**DRAFT
Addendum #5**

**The Parkside Neighborhood Center
and Affordable Housing
Mellen & Grant Streets,
Portland, Maine 04101**

May 3, 2004

The purpose of this ADDENDUM is to respond to questions, provide coordination and clarification to the previous drawings and specifications.

BUILDING A
A1.3

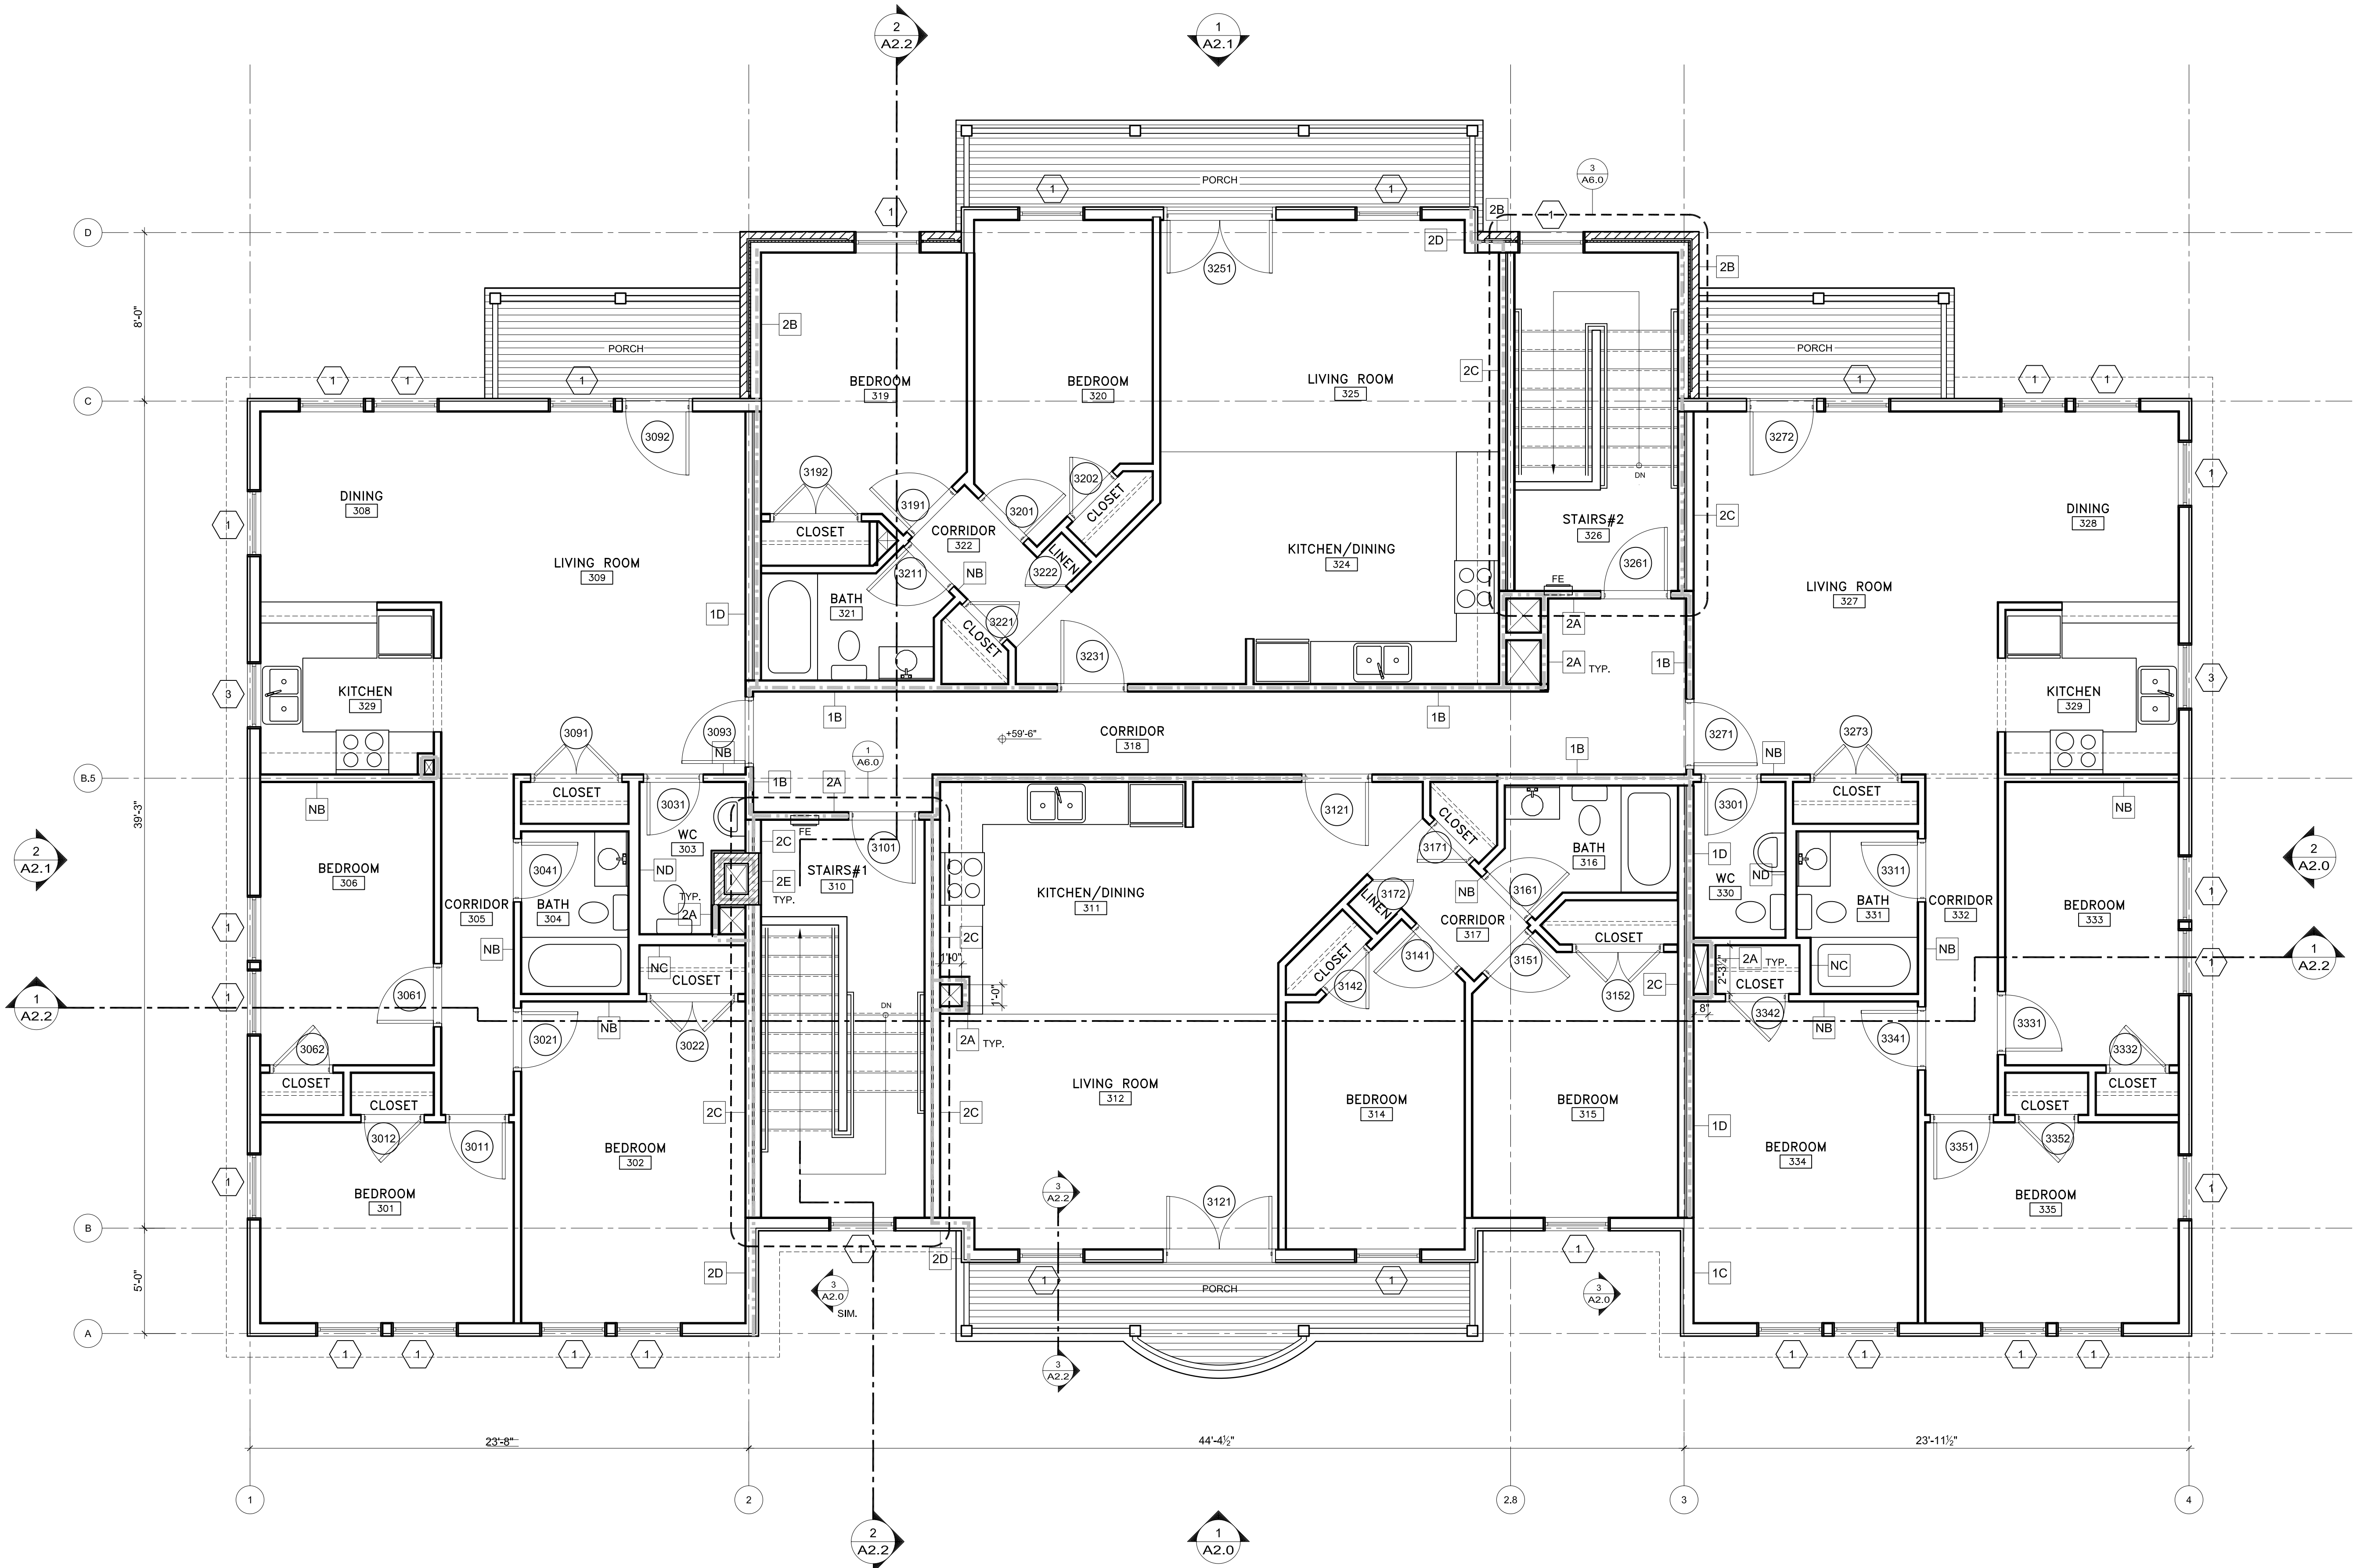
4-37	A-A1.2	1	ADD door tag #2261 to Stairs #2 226 door.
4-38	A-A1.2	1	DELETE brick veneer on exterior of rooms Bedroom 219 & Stairs #2 226.
4-39	A-A1.2	1	REVISE chase wall assembly types as indicated.
4-40	A-A1.3	1	REVISE chase wall assembly types as indicated.
4-41	A-A1.3	1	REVISE corridor wall assembly type from 1B to 1Ba as indicated.
4-42	A-A1.3	1	DELETE brick veneer on exterior of rooms Bedroom 319 & Stairs #2 326.
4-43	A-A1.4	1	ADD indications for 1 hr protected assemblies at the top of each rated chase, to be located at the 3 rd floor/attic assembly.
4-44	A-A1.5	1	ADD indications for 1 hr protected assemblies at the bottom of the chases.
4-45	A-A1.5	1	ADD pattern to soffit board outside Vestibule 014.
4-46	A-A1.6	1	ADD indications for 1 hr protected assemblies at the bottom of the chases.
4-47	A-A1.6	1	ADD recess for projector screen in Community Rm 113
4-48	A-A2.0	1	Tile mosaic location revised. Granite cap thickness revised.

BUILDING A
A2.2

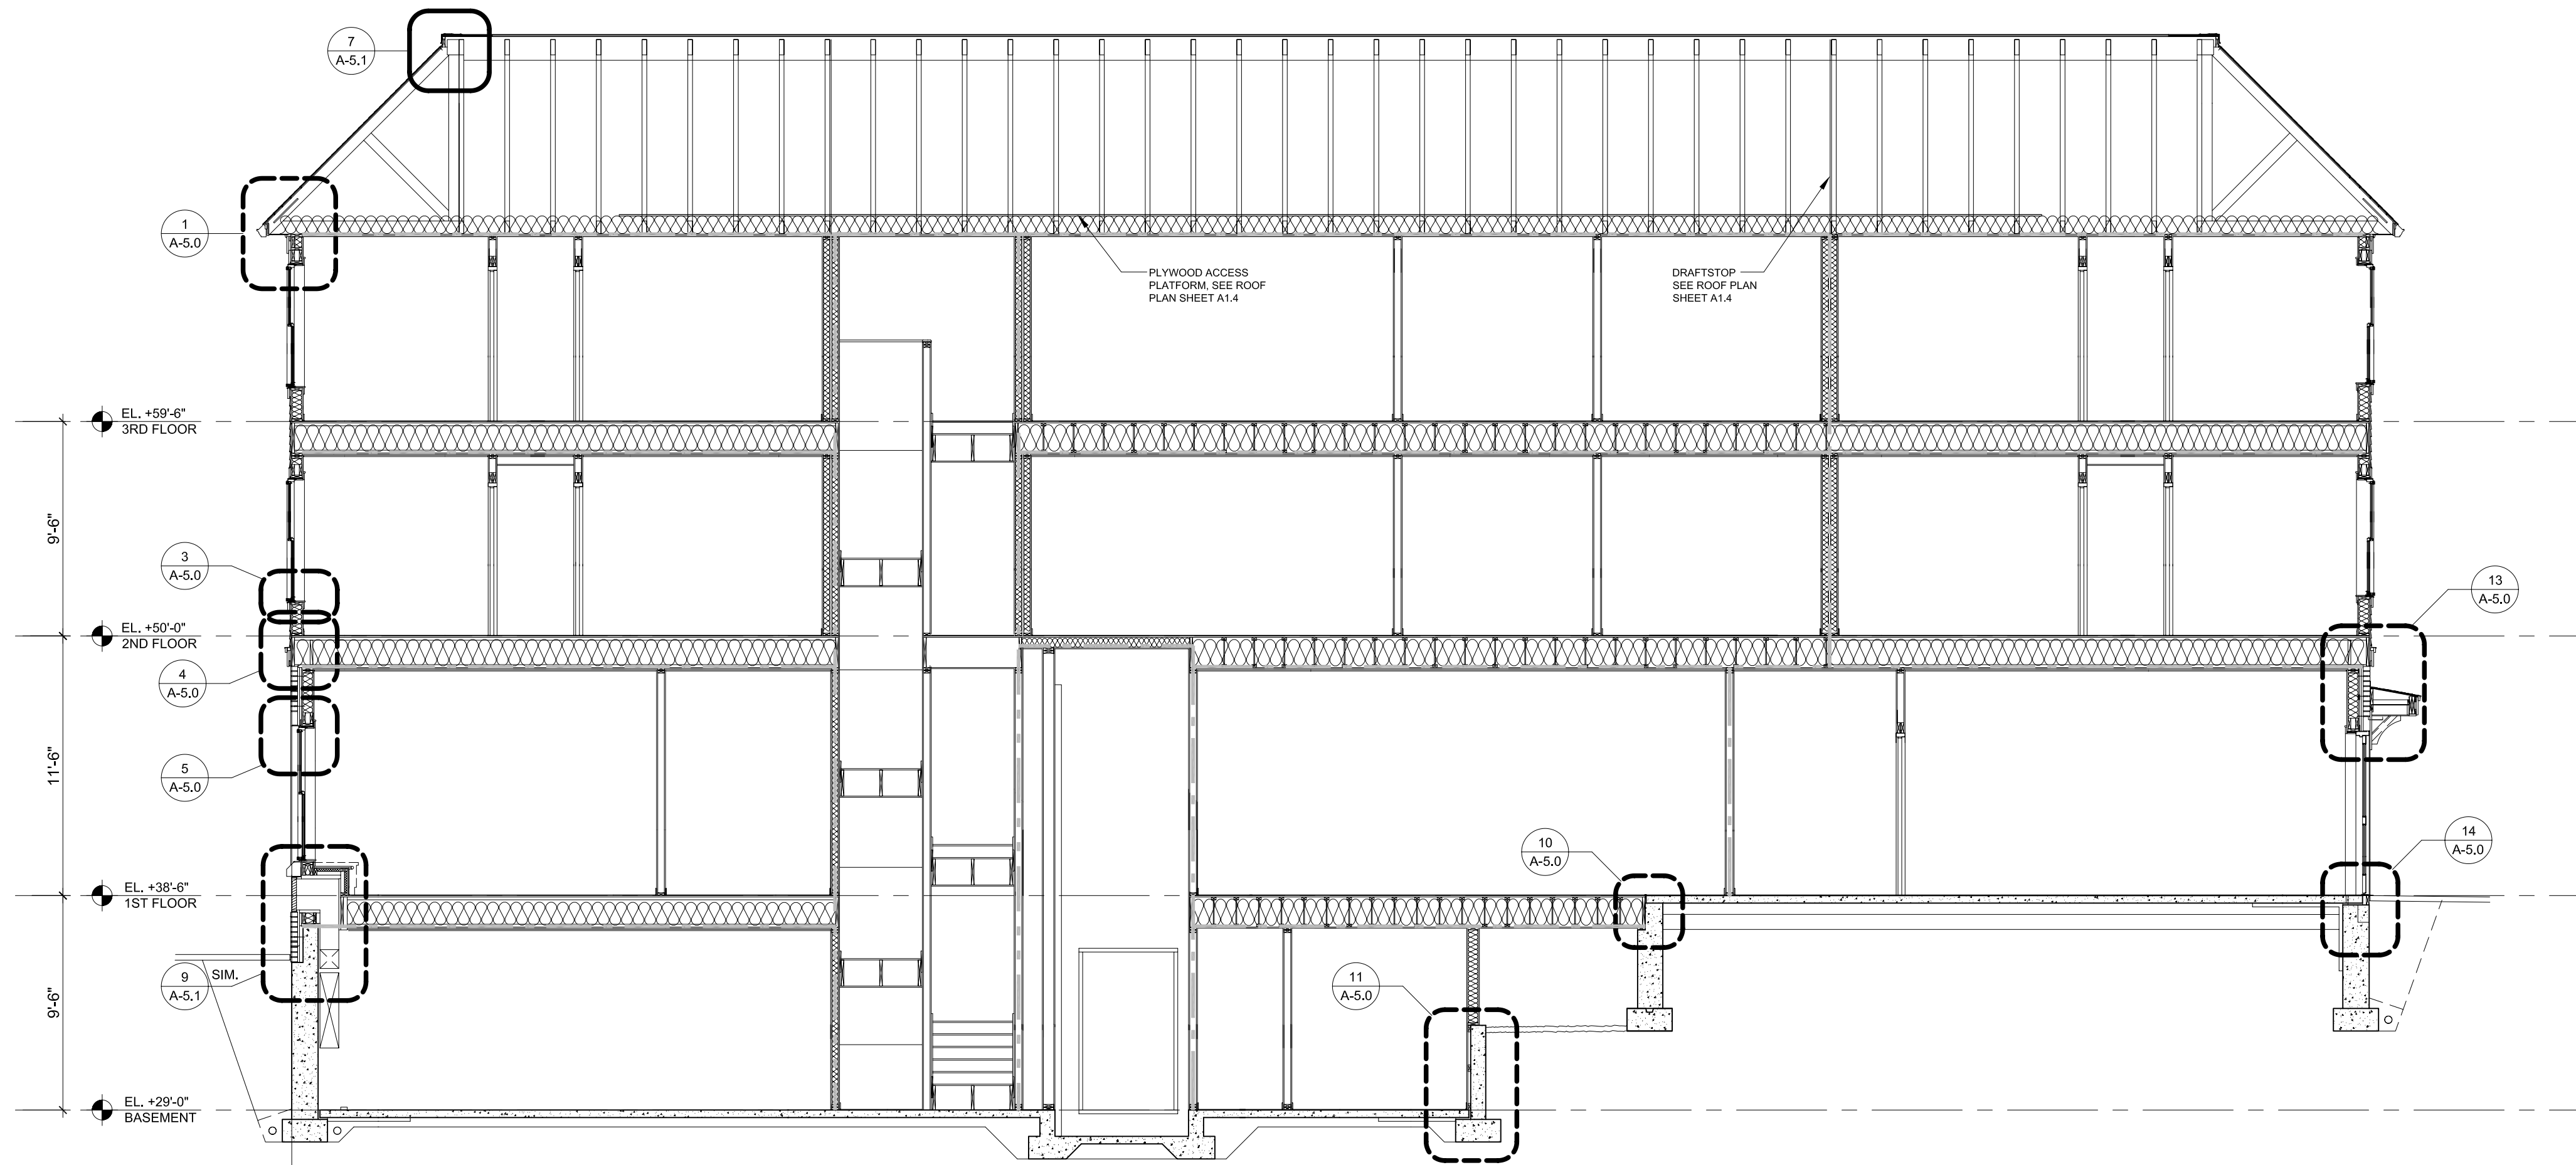
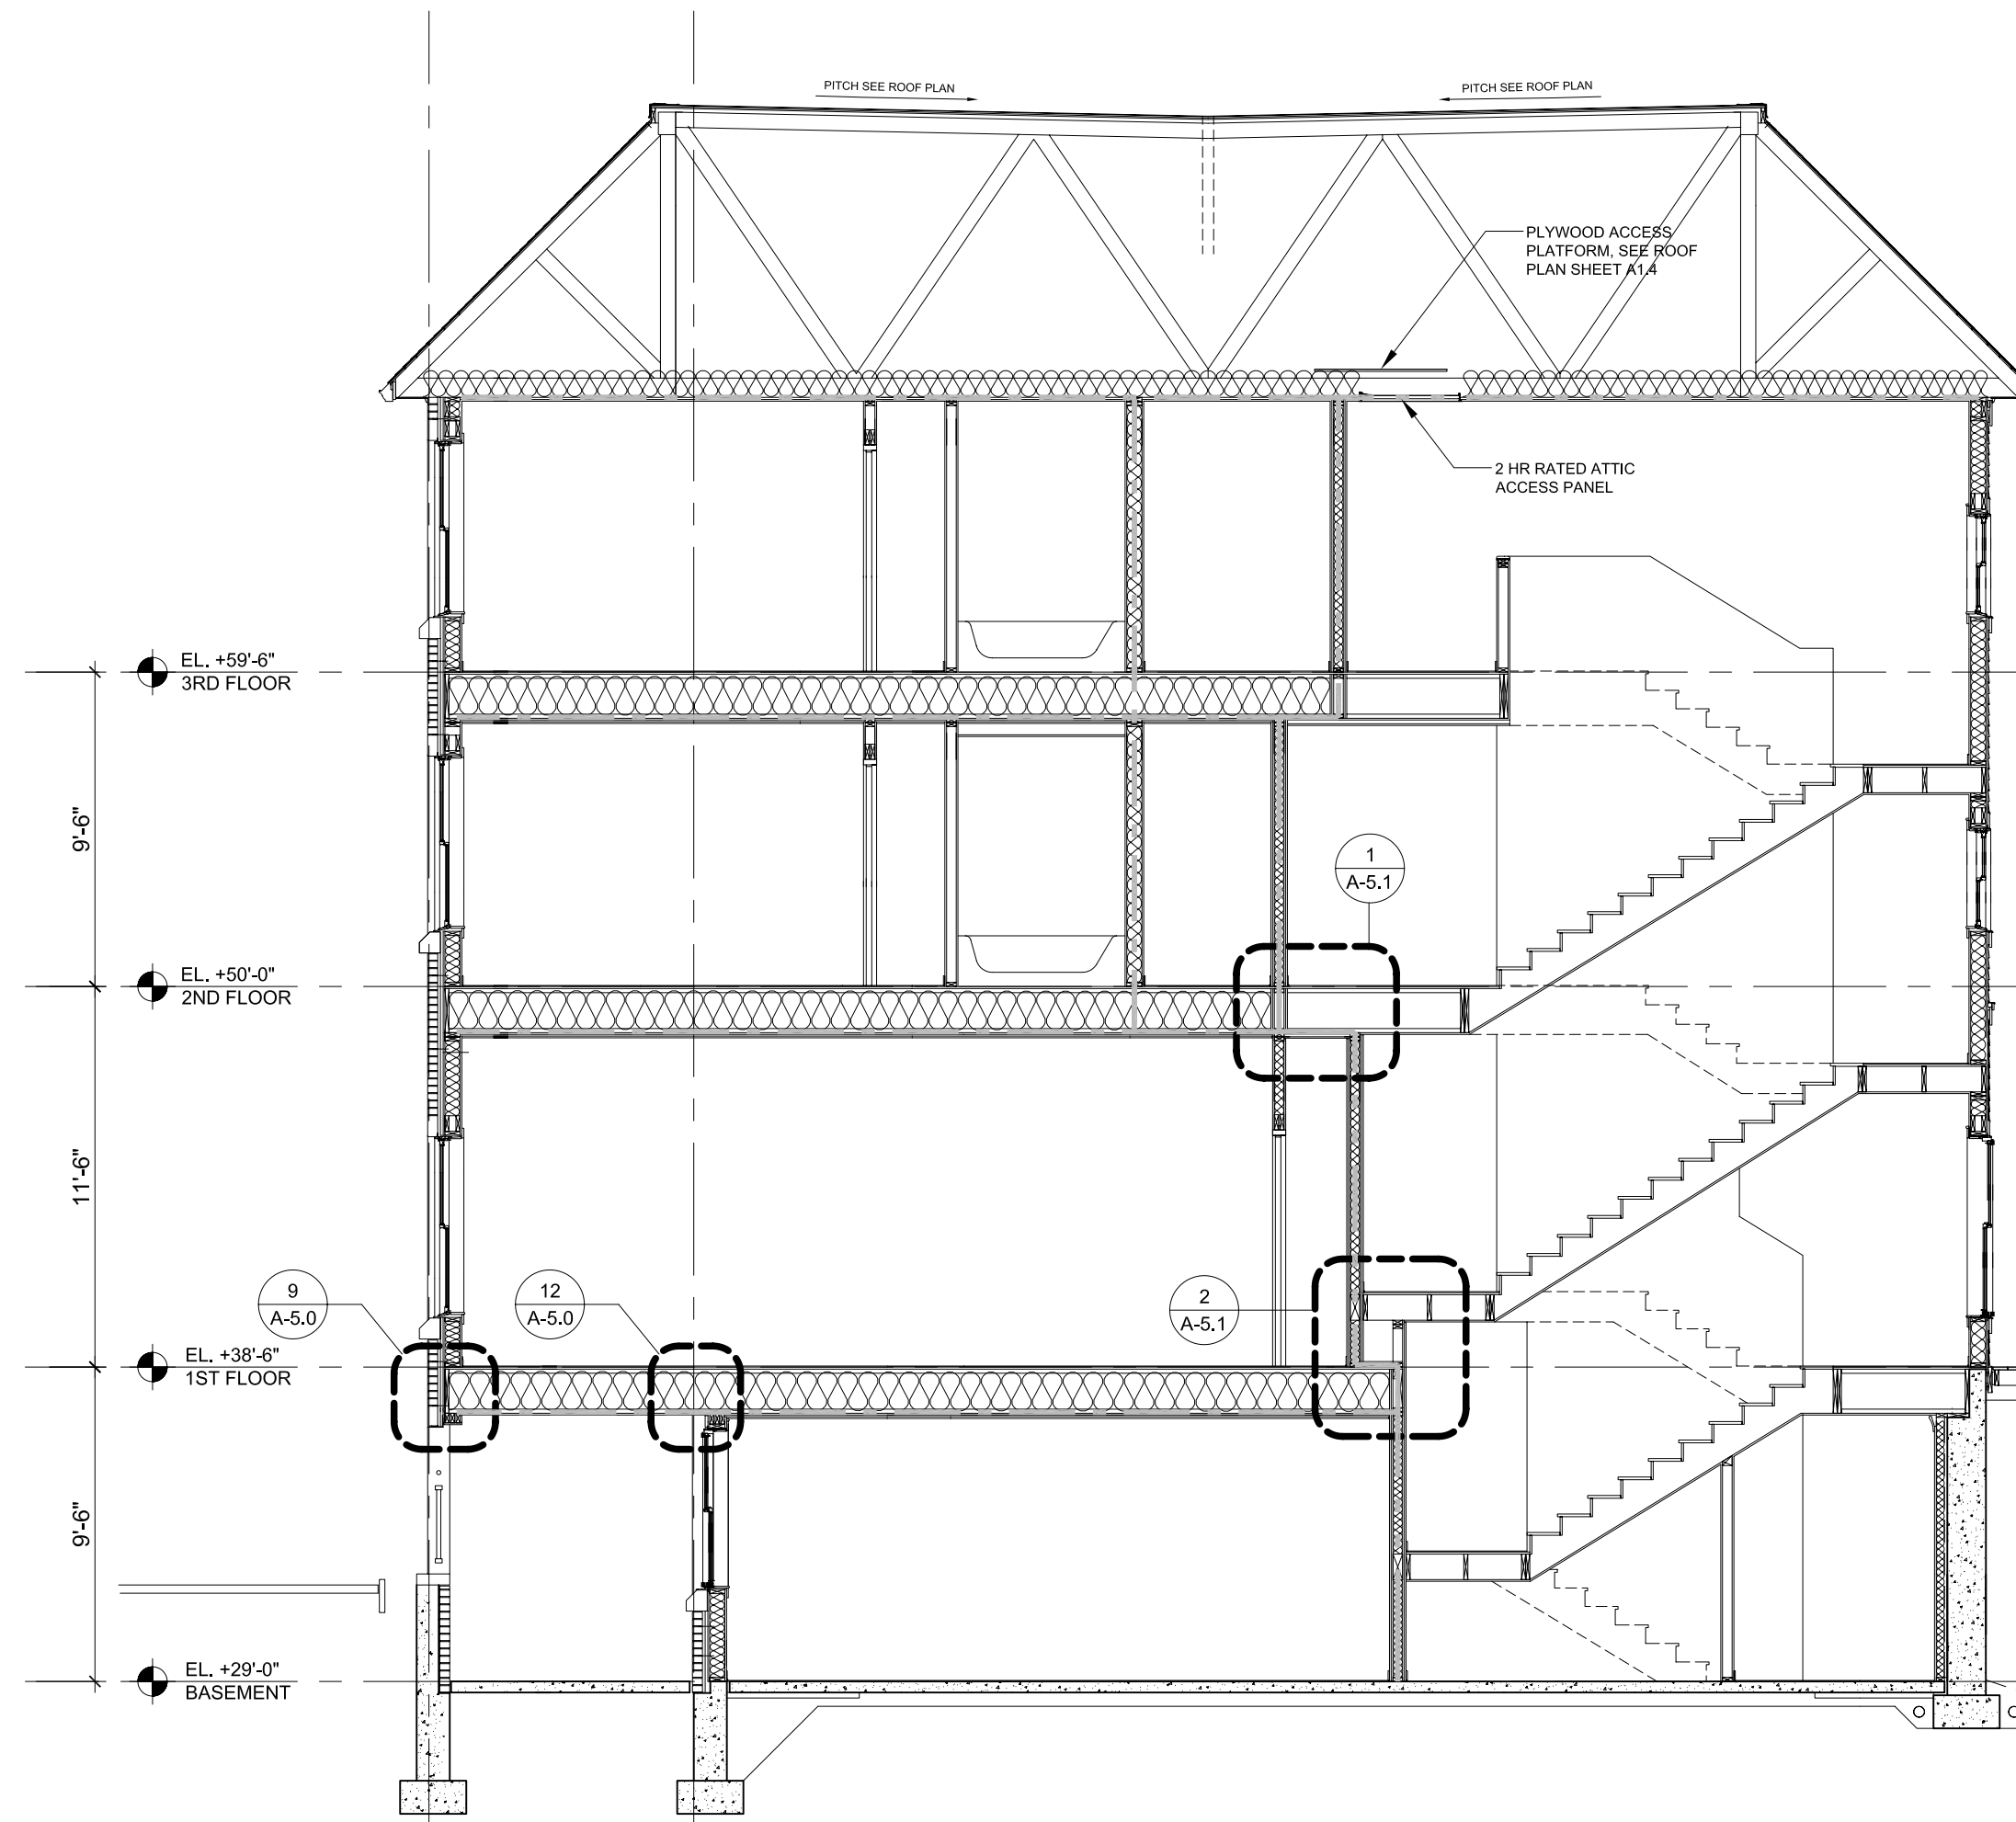
4-49	A-A2.0	2	Tile mosaic location revised. Brick veneer removed from north side bumpout.
4-50	A-A2.1	1	Brick veneer removed from north side bumpout.
4-51	A-A2.1	2	Tile mosaic location revised. Brick veneer removed from north side bumpout.
4-52	A-A2.2	2	Fire assemblies indicated, rating lines increased in visibility.
4-53	B-A1.0	1	DELETE chimney, revise as indicated.
4-54	B-A1.1	1	DELETE chimney, revise as indicated. REVISE chase wall assembly types as indicated.
4-55	B-A1.2	1	DELETE 1 window from rm. 131 Living Room. DELETE chimney, revise as indicated. REVISE chase wall assembly types as indicated. DELETE 1 window from rm. 224 Living / Dining Room.
4-56	B-A1.3	1	DELETE chimney, revise as indicated. REVISE chase wall assembly types as indicated. DELETE 1 window from rm. 327 Bedroom.
4-57	B-A1.4	1	ADD indications for 1 hr protected assemblies at the top of each rated chase, to be located at the 3 rd floor/attic assembly.
